Application Reference: 2026/0443

Site Address: 170 Sheffield Road, Birdwell, Barnsley, S70 5TD

Proposal: Demolish existing rear single storey extension and erection of 2 storey extension and formation of off-street parking spaces.

Drawing Title: PROPOSED FLOOR PLANS,  
ELEVATIONS & SITE LAYOUT

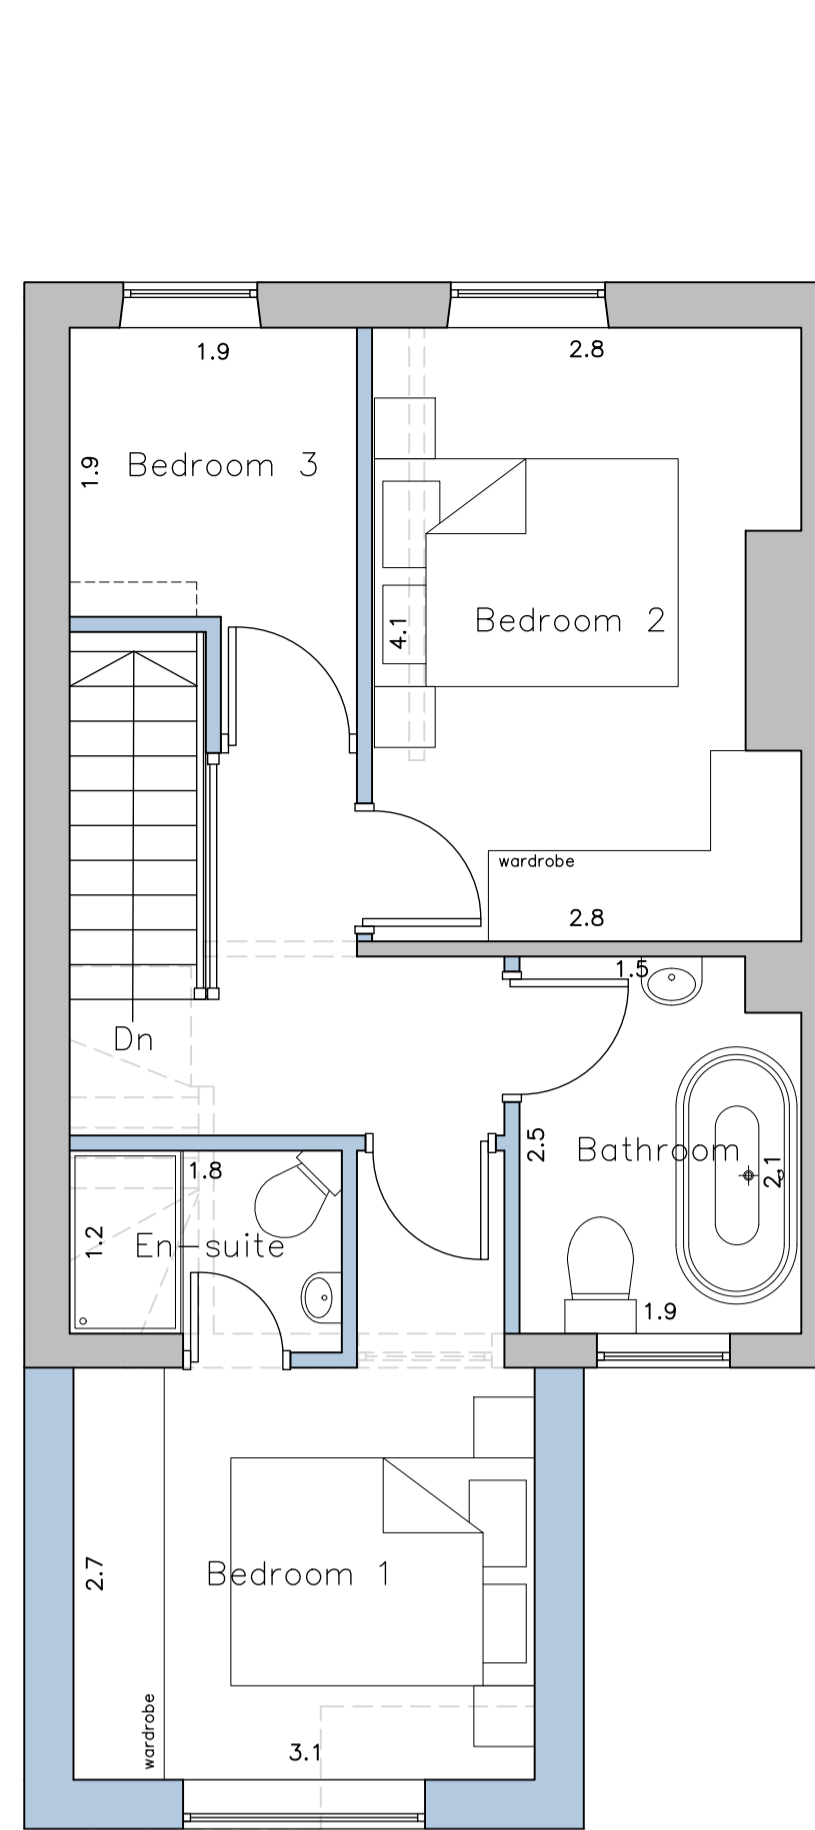
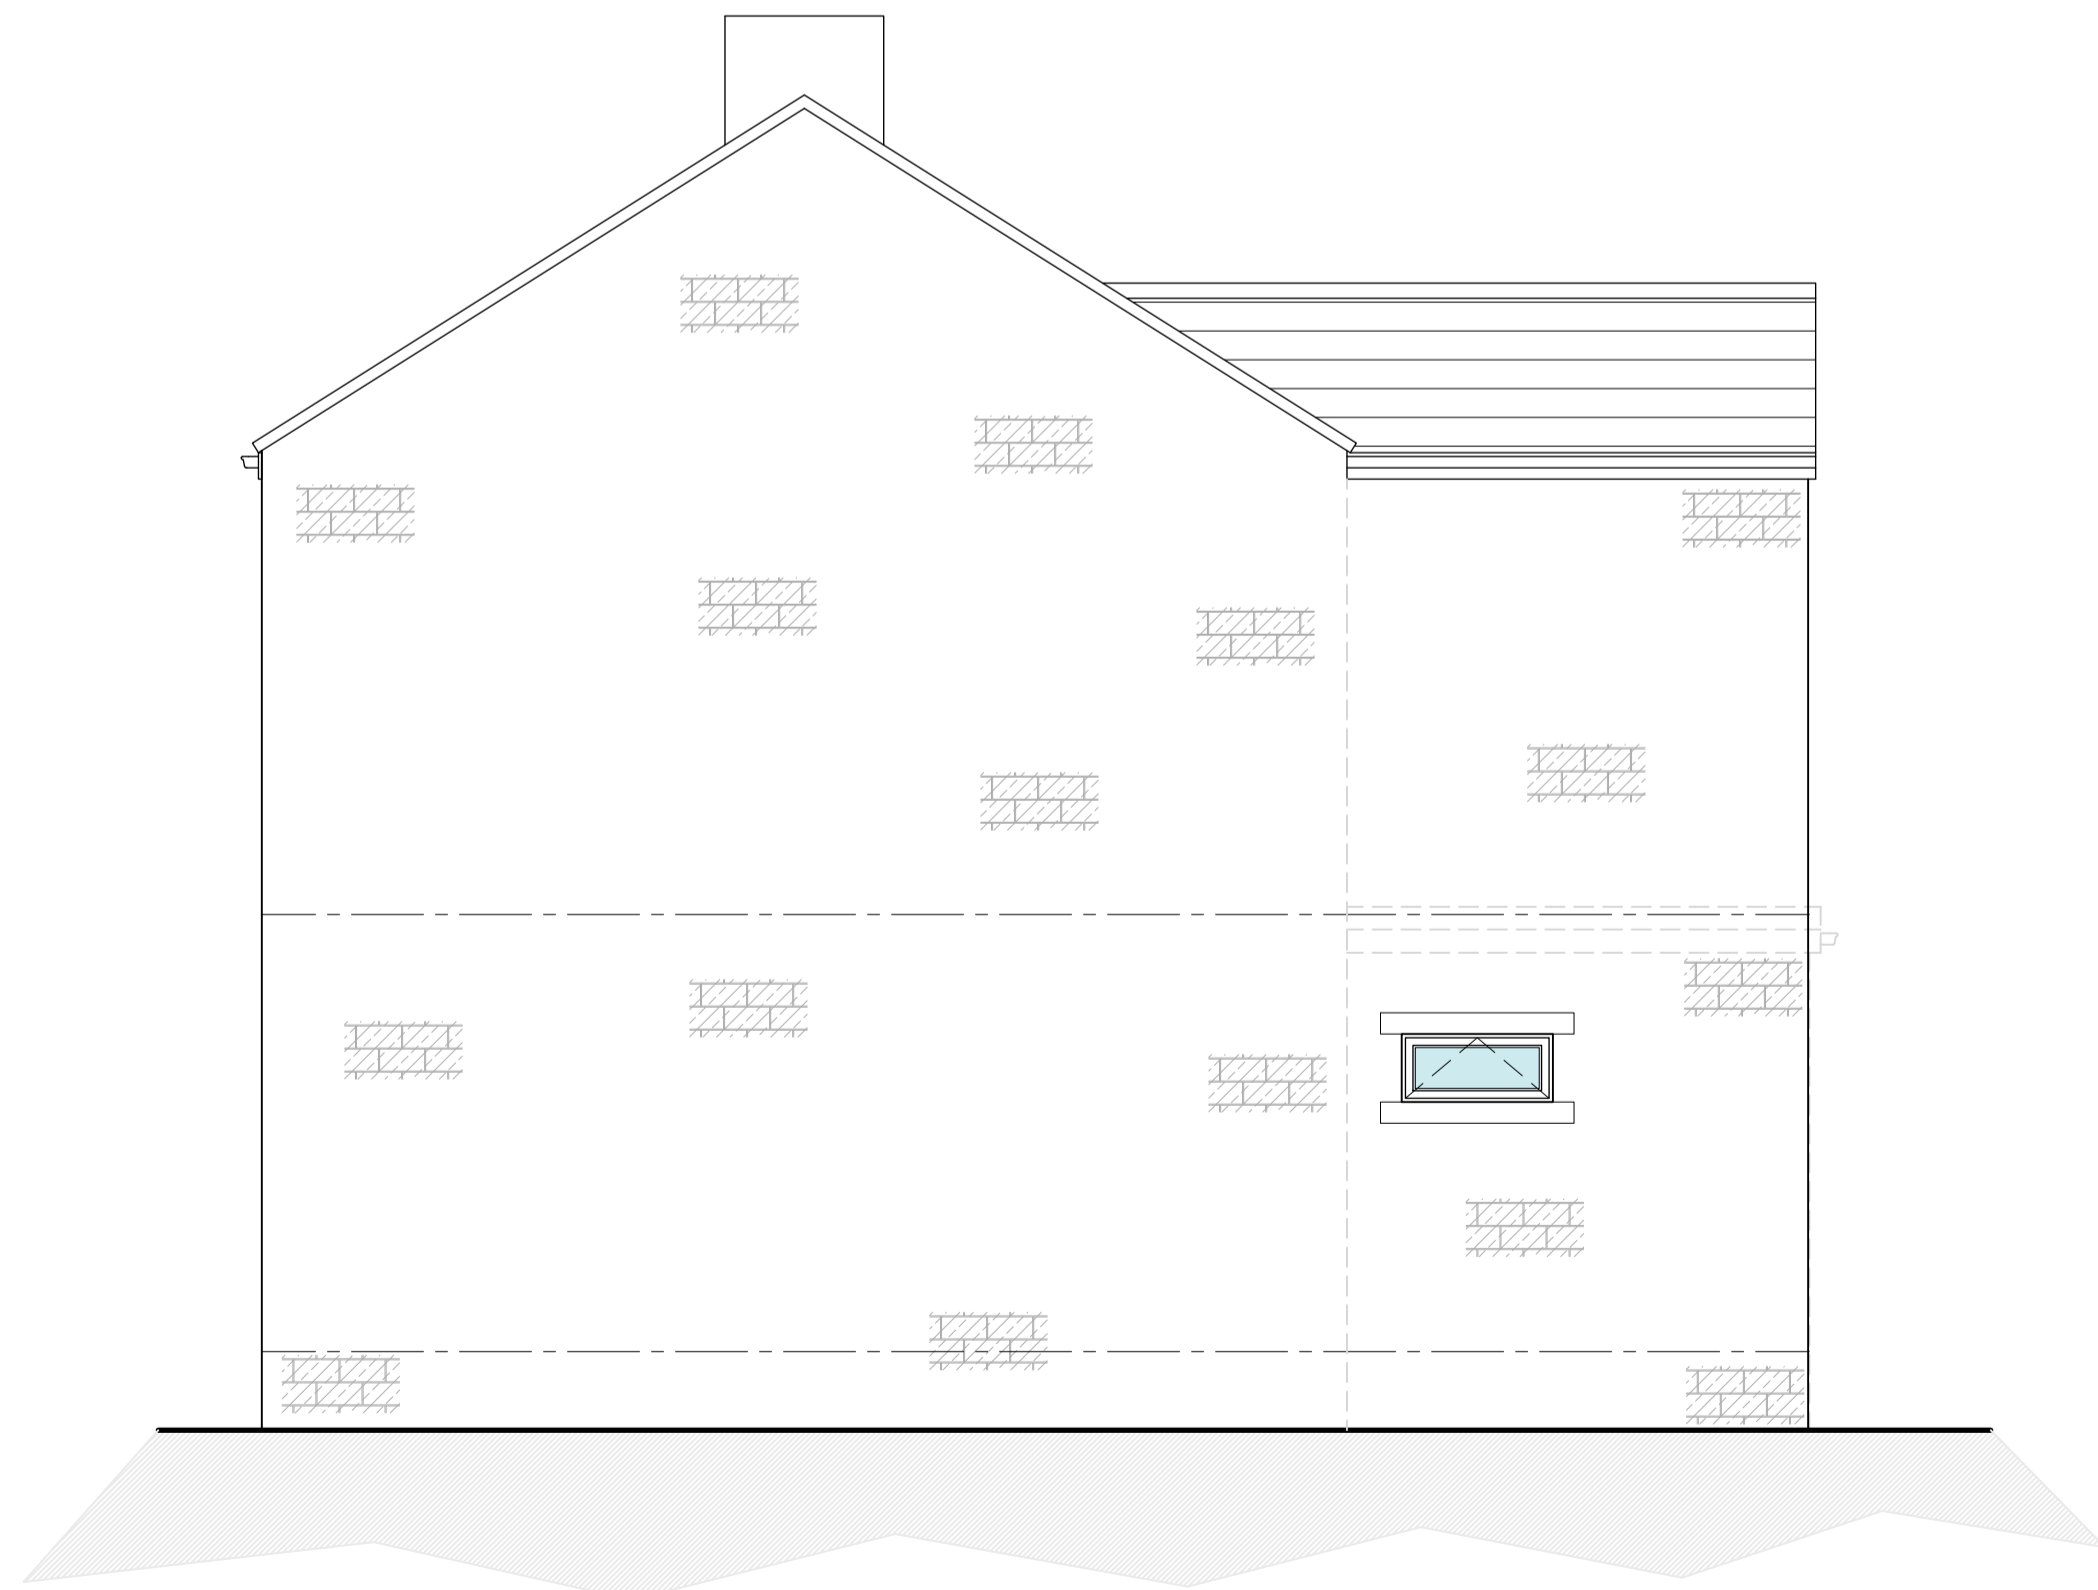
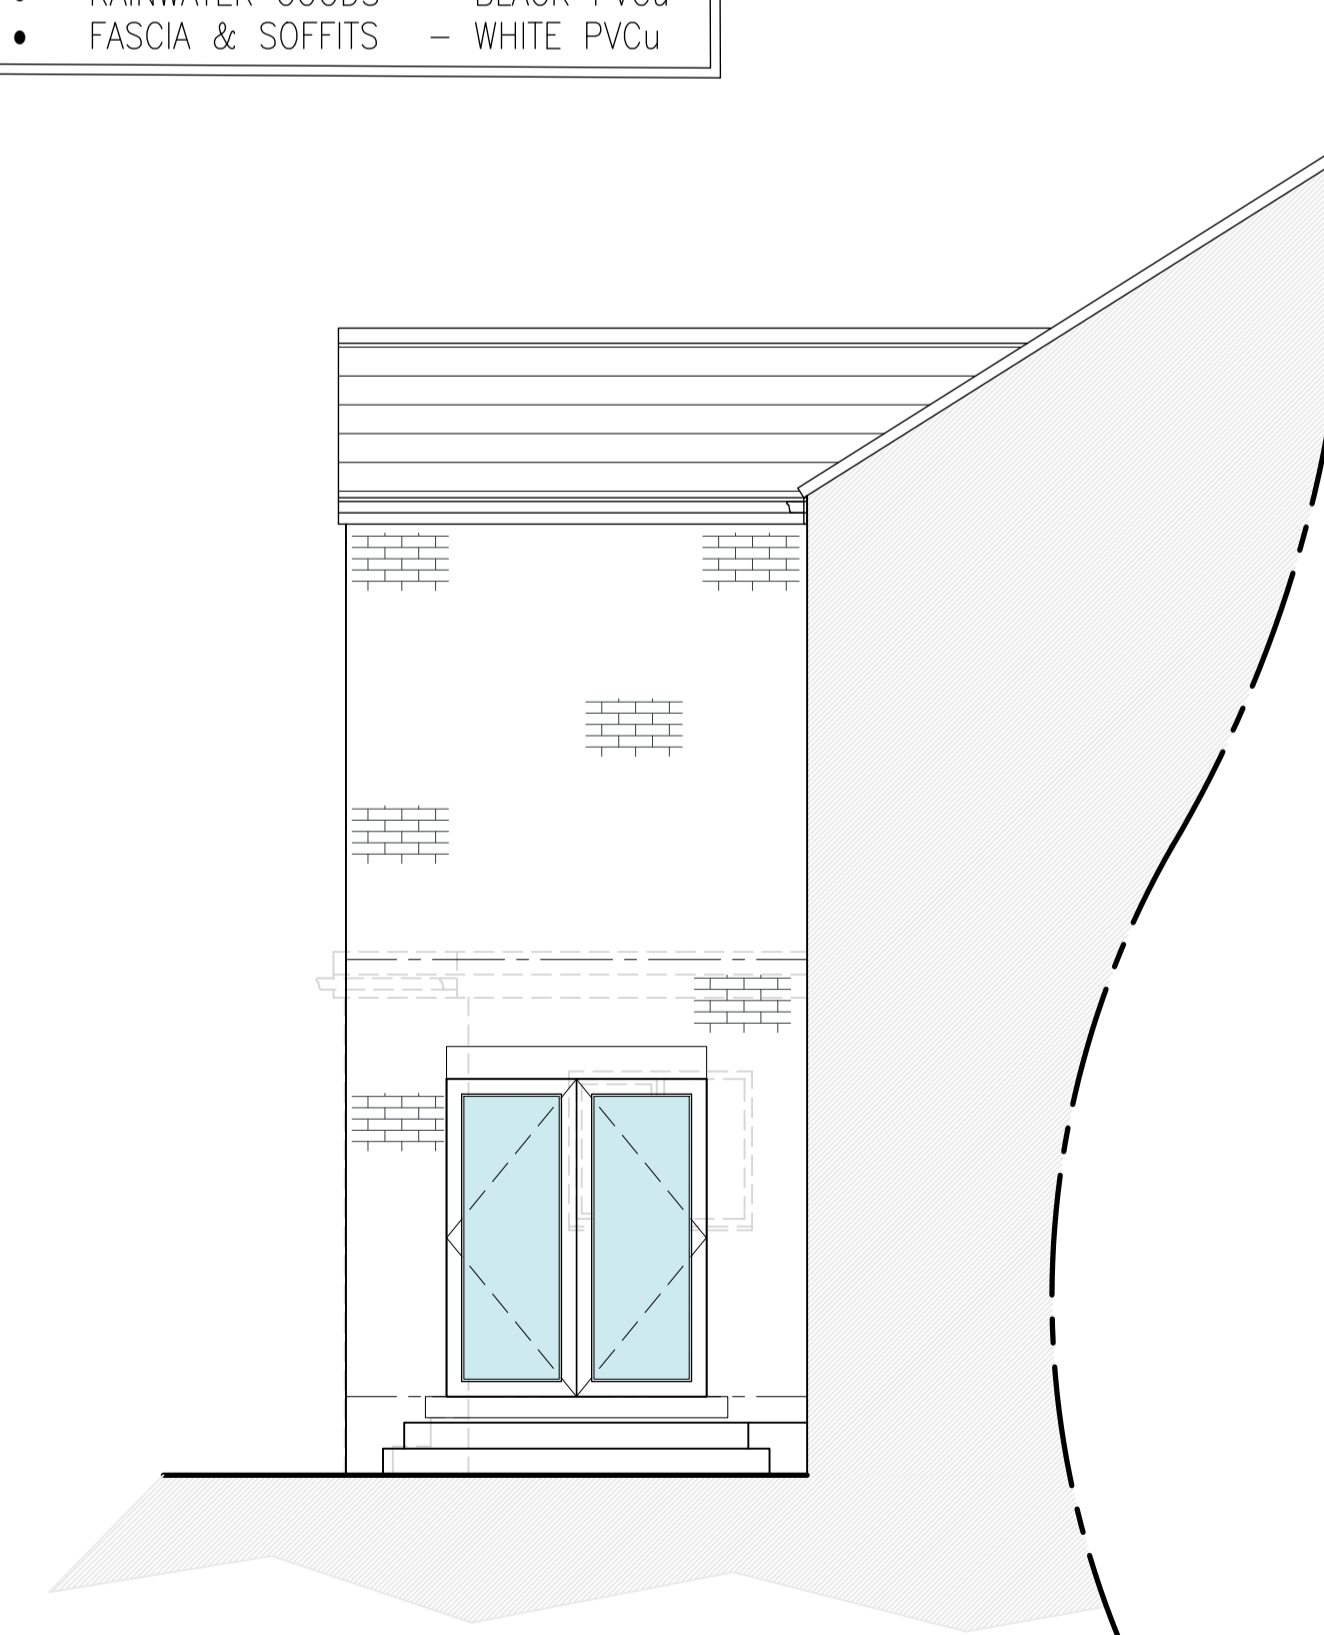
The rear projection of approximately 3 metres is acknowledged to exceed what is generally allowed for two storey extensions to the rear of terraced dwellings. However, the projection would only exceed the guidance by approximately 0.5 metres and would not exceed the rear projection of the extension of the neighbouring dwelling to the north of the site and other neighbouring extensions.

A modest eaves height has been proposed which matches the existing dwelling and the ridge height is set down below the existing ridge height, ensuring the proposal remains subordinate to the dwelling. The proposed glazing matches the existing dwellings fenestration and is not considered controversial. The use of matching materials allows the proposal to remain in keeping with the dwelling.

The proposed extension would be erected to the north of the adjoined neighbouring property. The extension would therefore only provide limited overshadowing to the south. The extension is set away from the adjoined property by approximately 1.5 metres, reducing the dominance of the proposal. No glazing is proposed to the south elevation at first floor level, preventing any opportunity for overlooking from the bedroom. The ground floor patio doors do face the neighbouring property, however, are screened by significant boundary treatment and do not service a habitable room. The screening also helps to reduce the impact of the proposal.

The proposal does not project further to the rear than the neighbouring property to the north and will therefore have no impact on neighbours located to the north of the site. The rear elevation of the proposal would be distanced to the amenity space to the west of the site by

The window proposed to the rear elevation at ground floor level to service a W/C shall be conditioned to be obscured glazing in order to protect the privacy of both the applicant and any neighbours using the right of way located to the rear of the dwelling.

The proposal would not increase the number of bedrooms on site or reduce the on-site parking facility. The application proposes to create two parking spaces to the rear of the dwelling within the currently overgrown area. This would improve the on-site parking facility and would elevate the current parking in what is already a densely populated area with limited parking facility. Furthermore, highways have expressed no concerns or objections to the proposed parking spaces.
